Martin Nugent
01254 828060
D3/12/1042

**Planning Application, Ribble Valley District
D3-12-1042 2 Walker Street, Clitheroe**

SITE PLAN 1:500

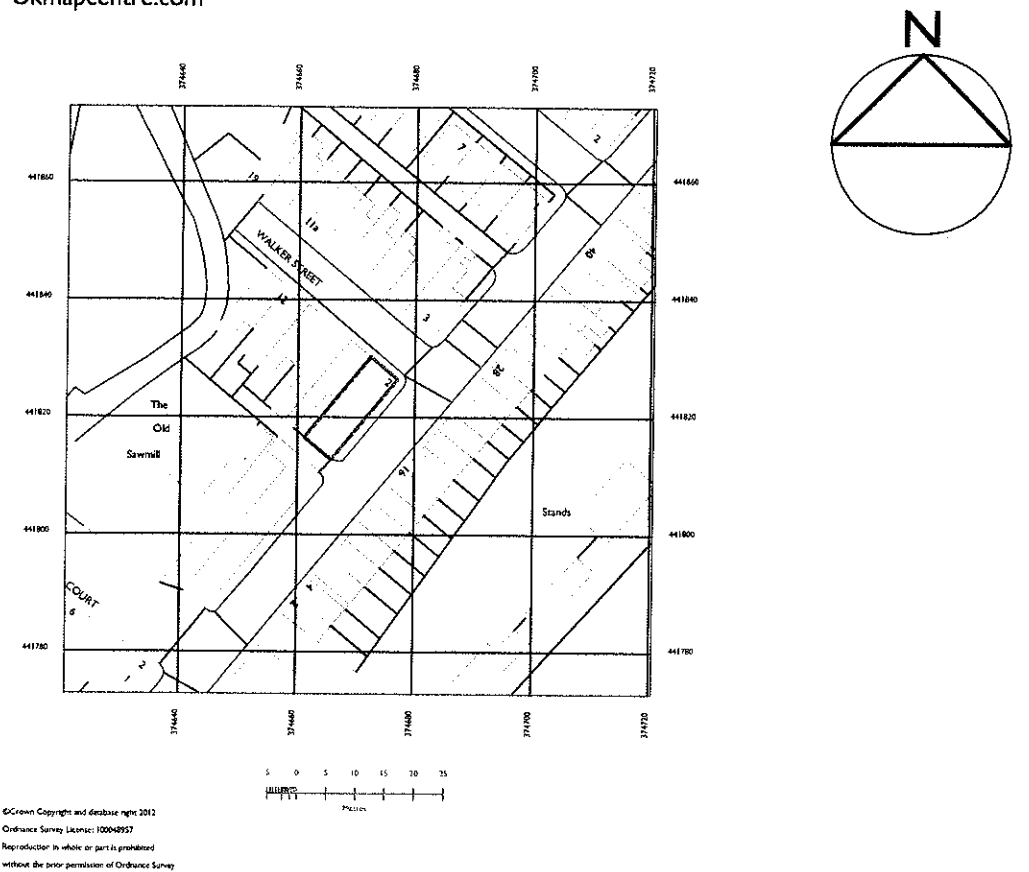
There is no detail on the site plan or elevation drawings identifying how the car parking area will be secured. Assuming this is to be gated in some way, it is not clear from the information provided how this will be achieved without a significant detrimental impact on the proposed parking/manoeuvring space available within the site curtilage.

I would ask that a revised site plan and elevations drawings be provided that show the proposed treatment of the entrance to the car parking area.
